Your Ref: OWPC4217
Our Ref: EP/149/14/PL 17-09-2014
Please ask for:
Mrs A Gardner

Construction of 3 bedroom dwelling with rooms in roof space. Resubmission of
EP/100/12

37 Orchard Road East Preston

Proposed Street Elevation

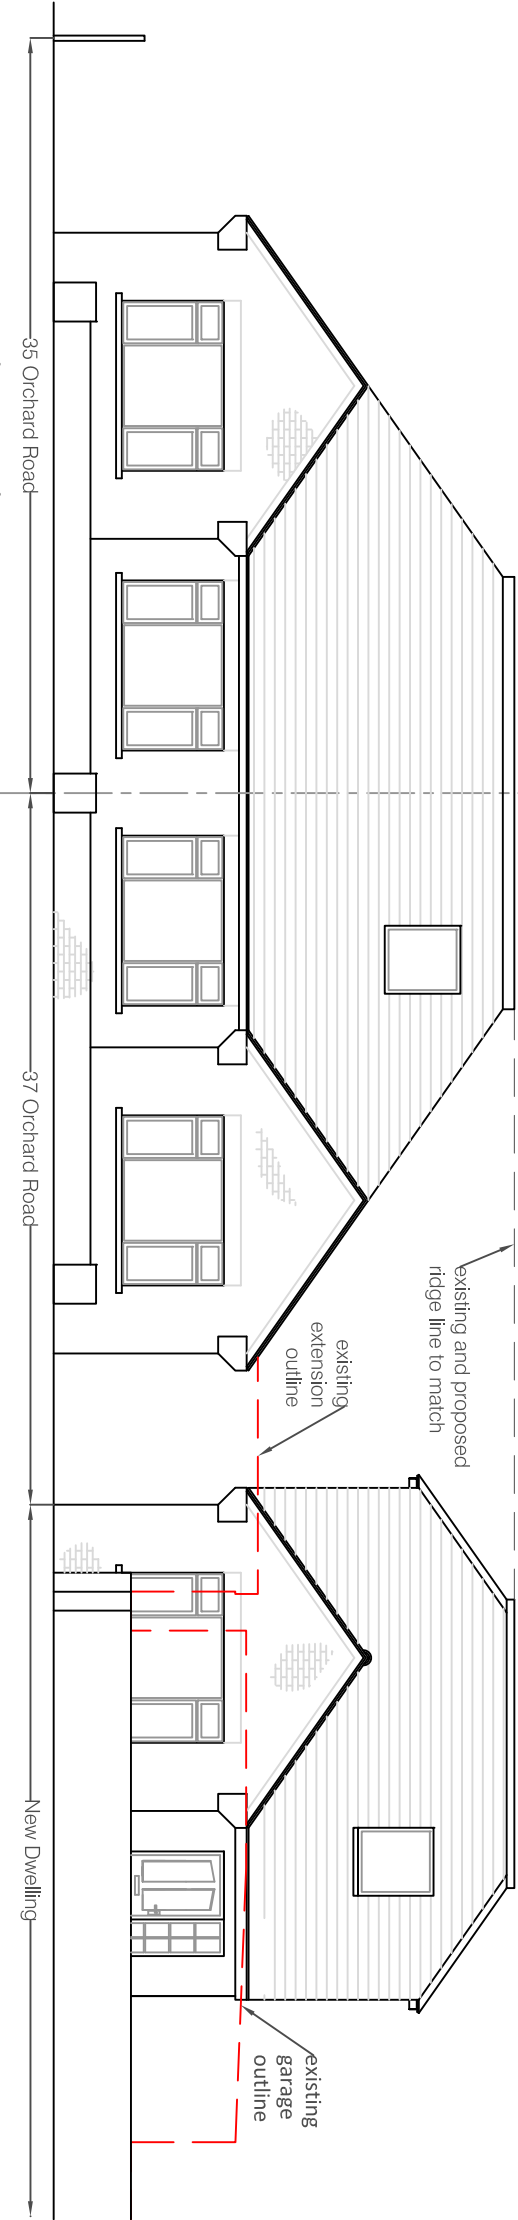
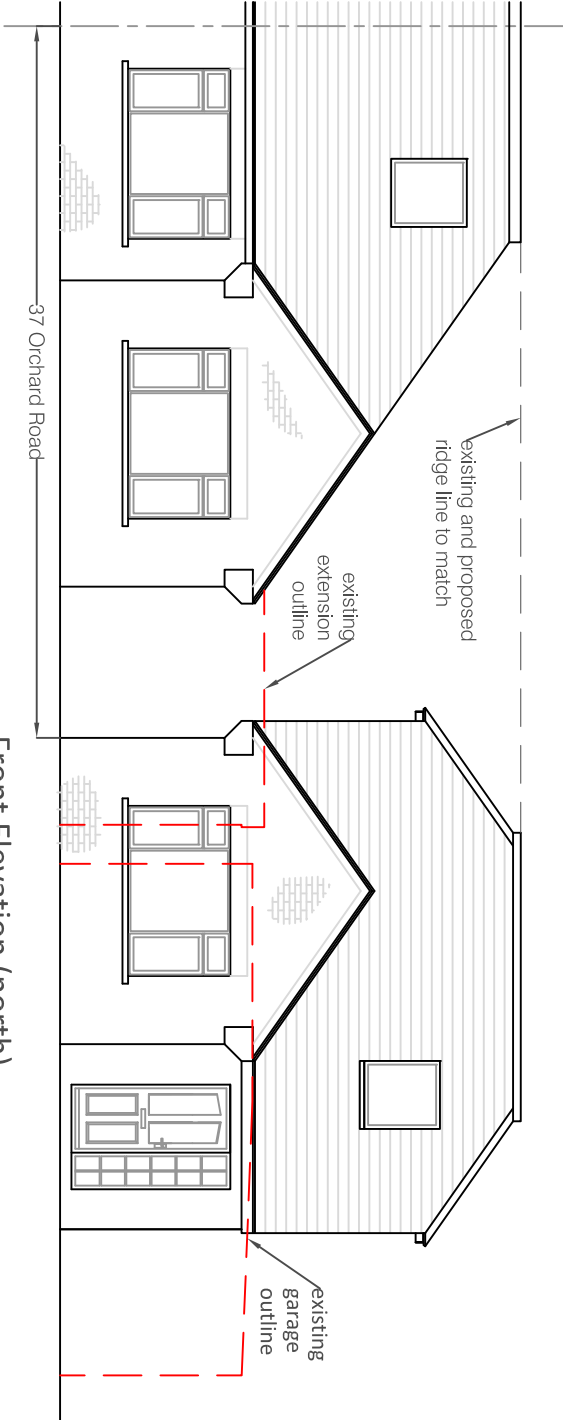
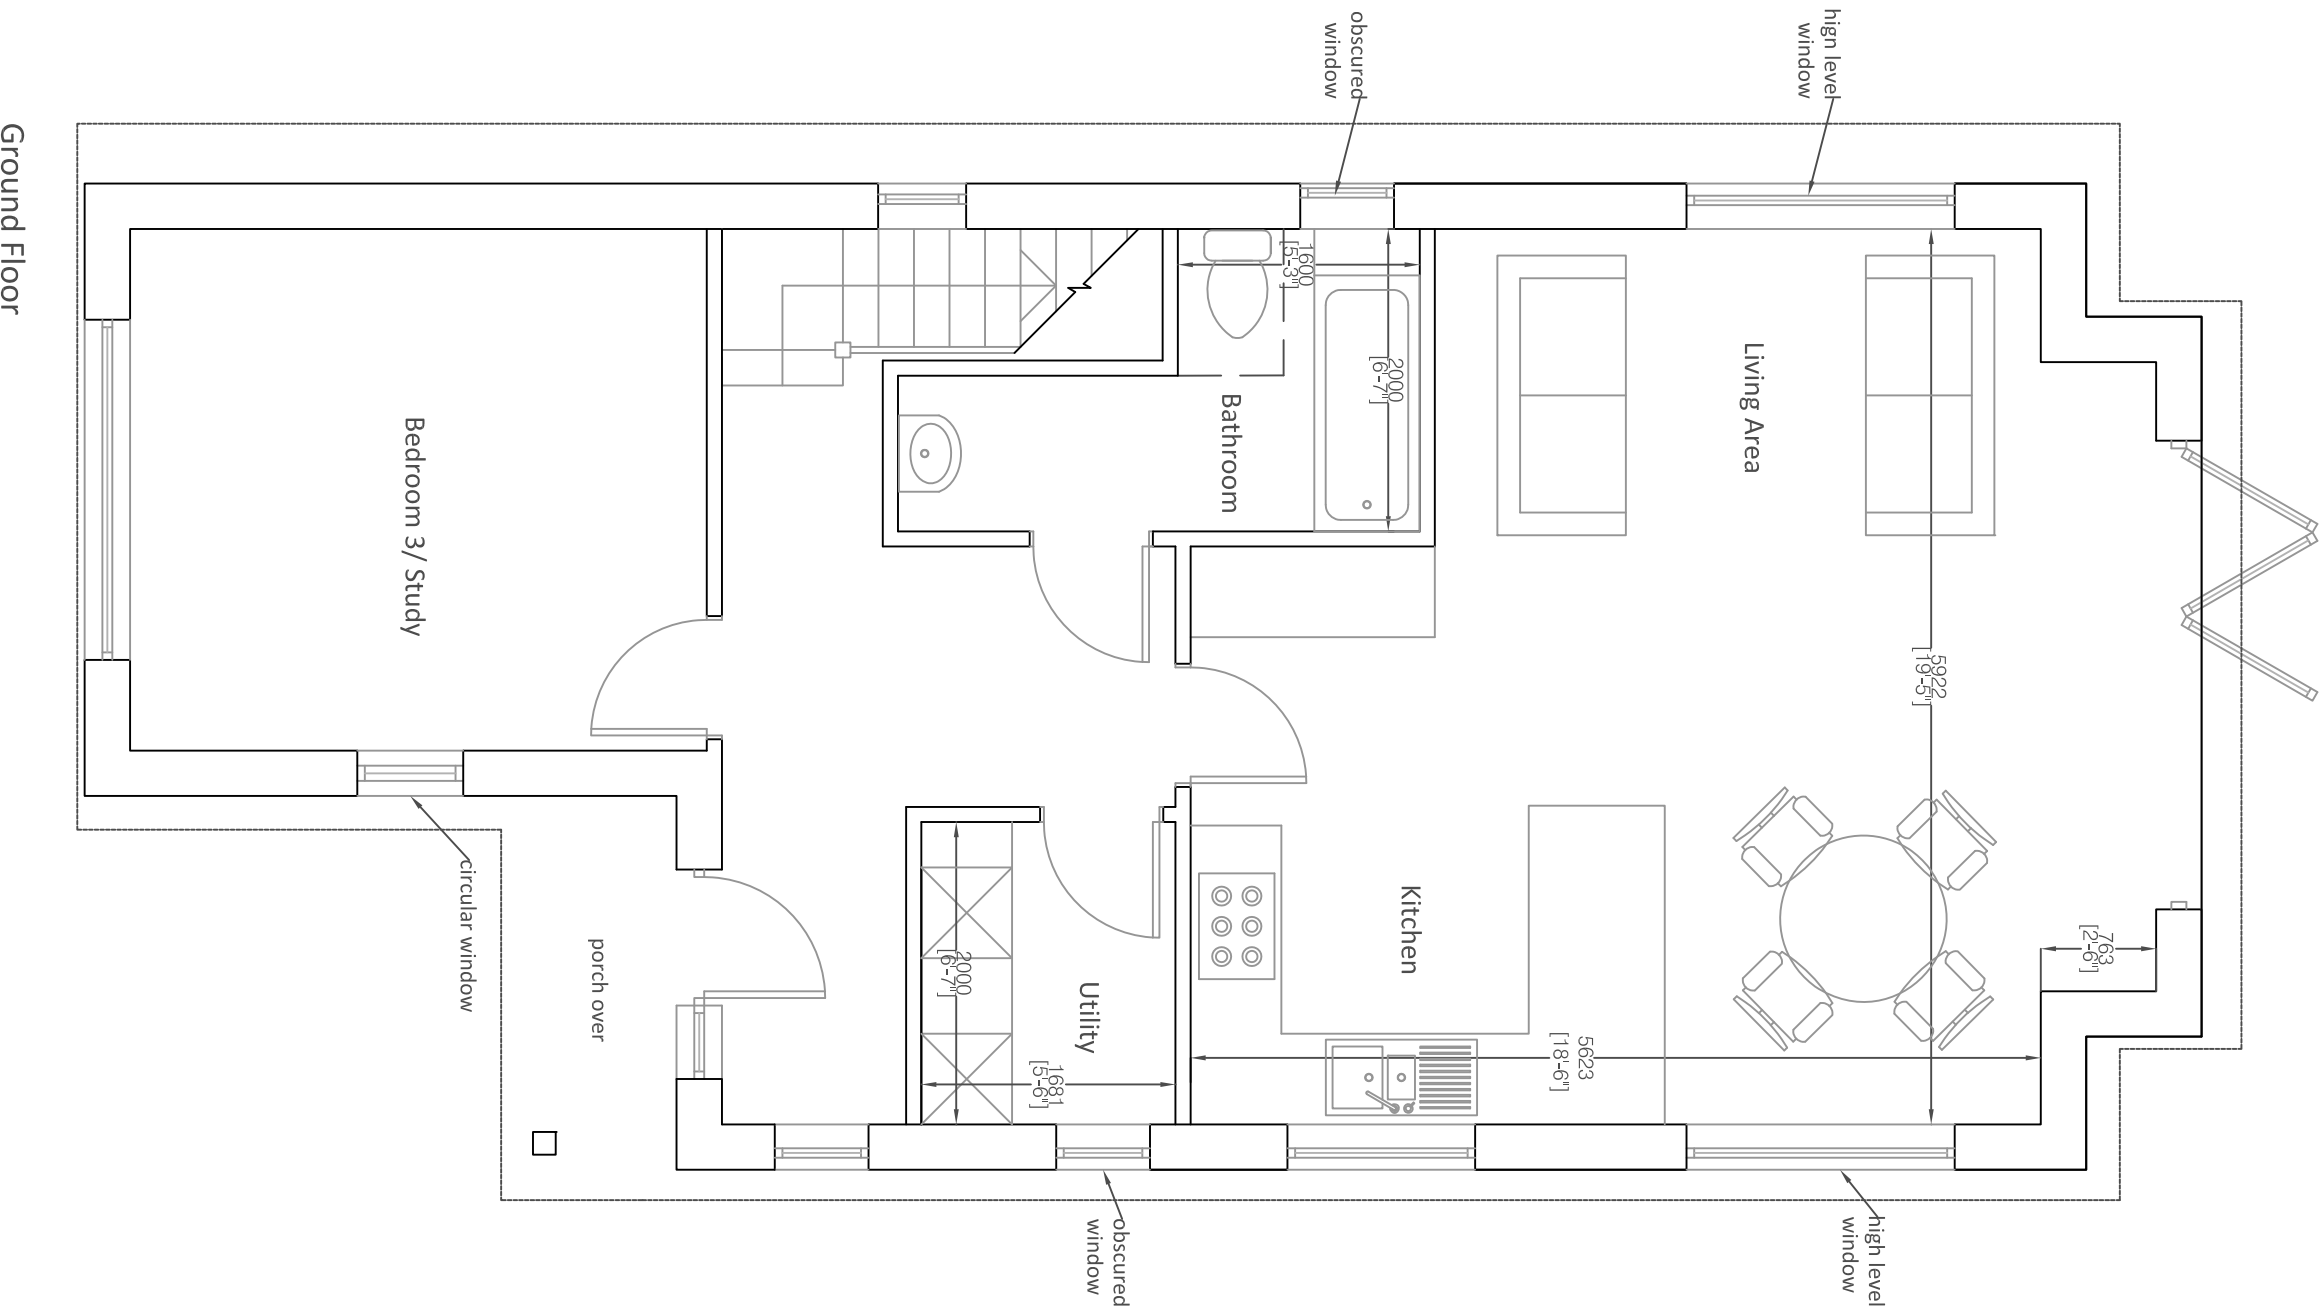
The proposed building is therefore poorly proportioned, being too narrow in relation to its height and quite different from the proportions of its existing neighbour to the west. It also present a facade that is dominated by the front slope its roof. Its design is contrary to Policy D SP1 of the Emerging Arun Local Plan, and Policy GEN7 of the Arun Local Plan.

Rear Elevation (south)

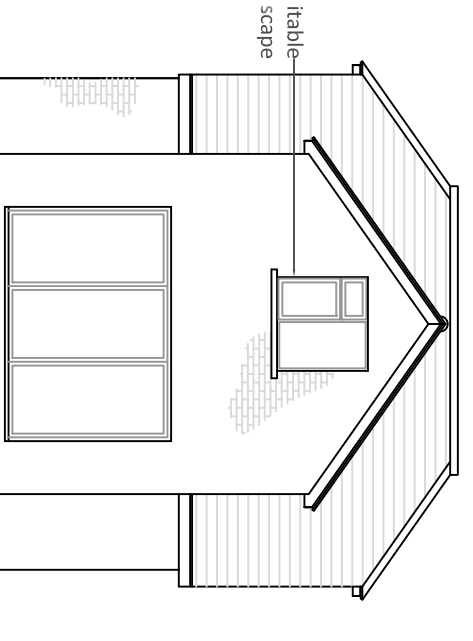
The windows of the two bedrooms upstairs would overlook the rear of the properties in Windlesham Gardens to the south and Orchard Road to the west, reducing the privacy these properties now enjoy. This feature is contrary to Policy D DM1. 3 Impact of the Emerging Arun Local Plan, and Policy GEN7 of the Arun Local Plan.

Ground Floor

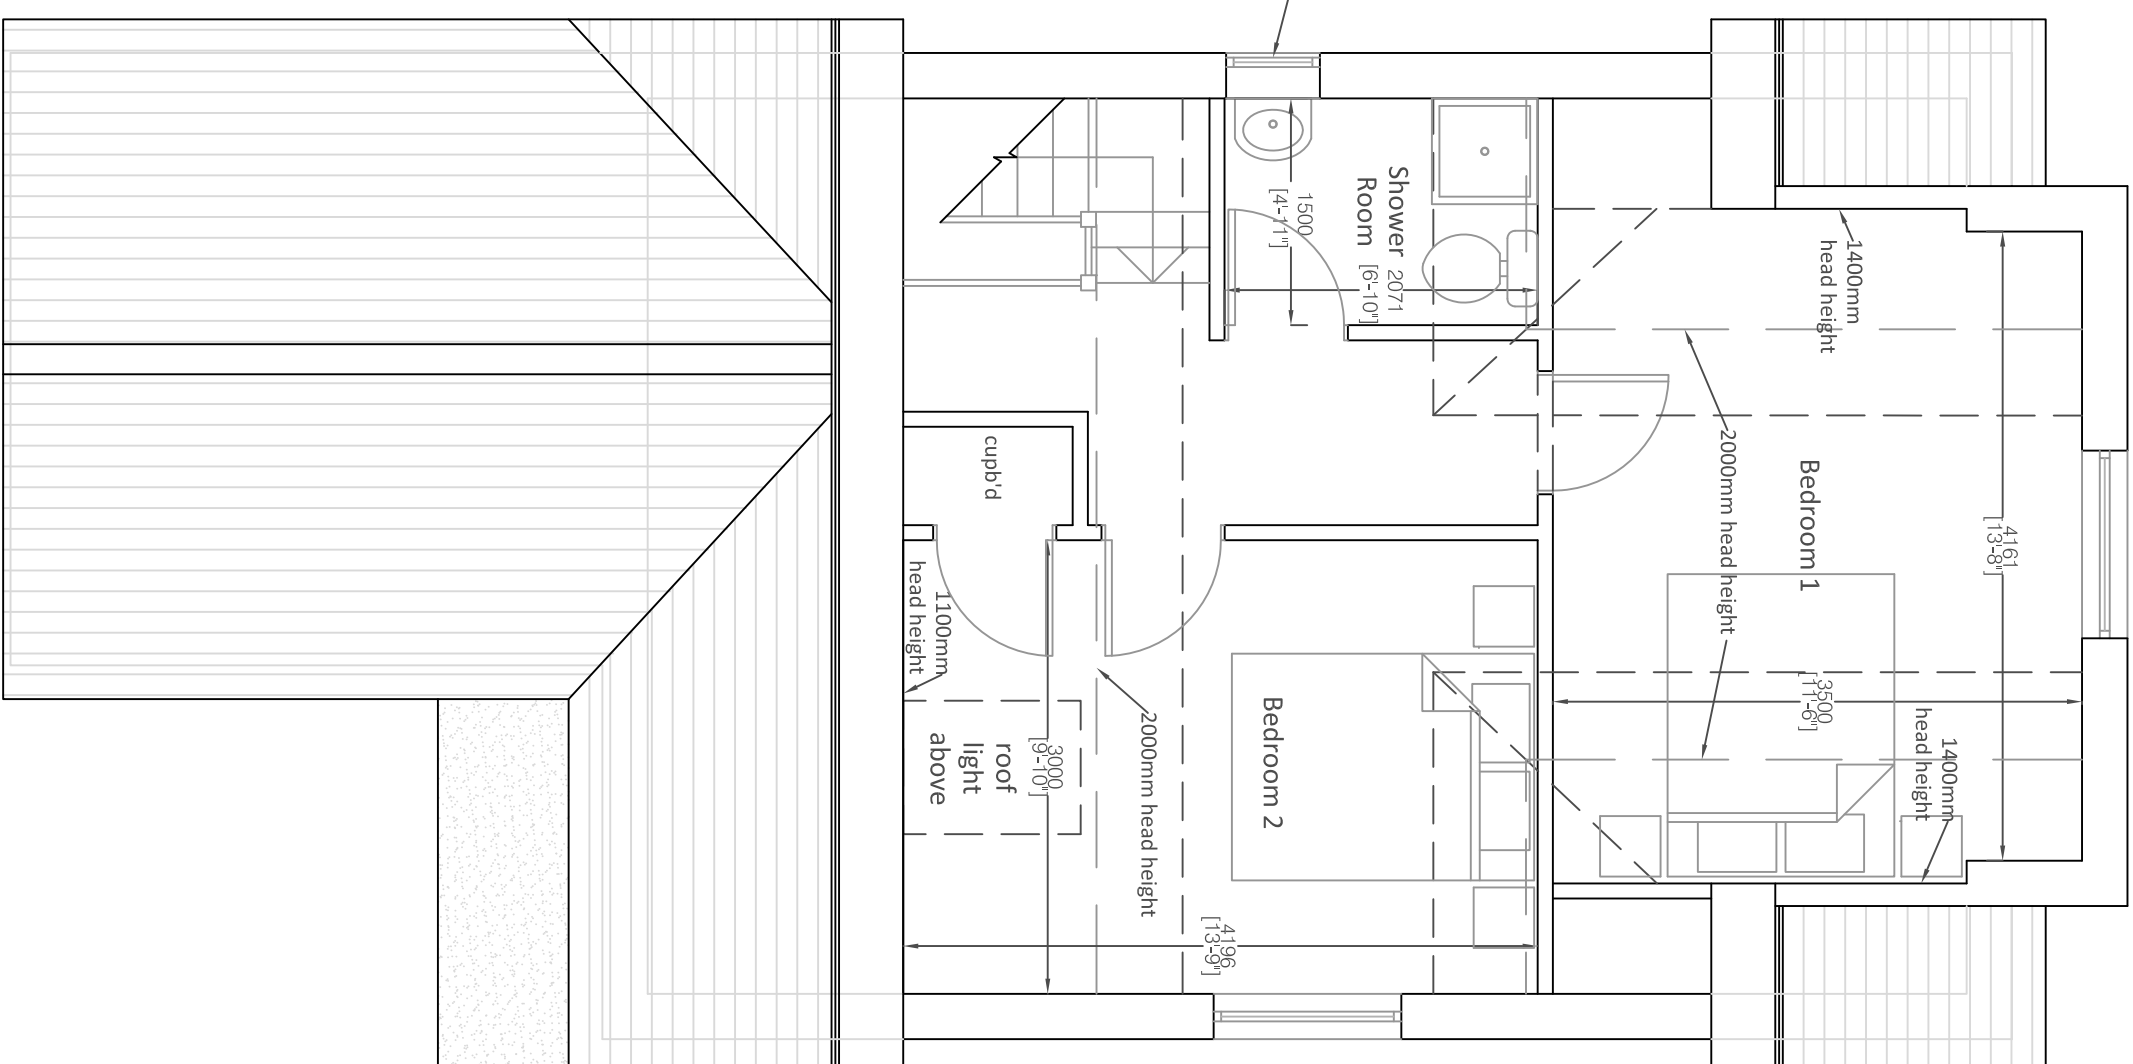
The provision for parking in the front garden assumes that two cars can satisfactorily be parked one behind the other. This kind of provision is liable to lead to an increase in on-road parking, and is contrary to policy 1. (ii) of the emerging East Preston Neighbourhood Plan.
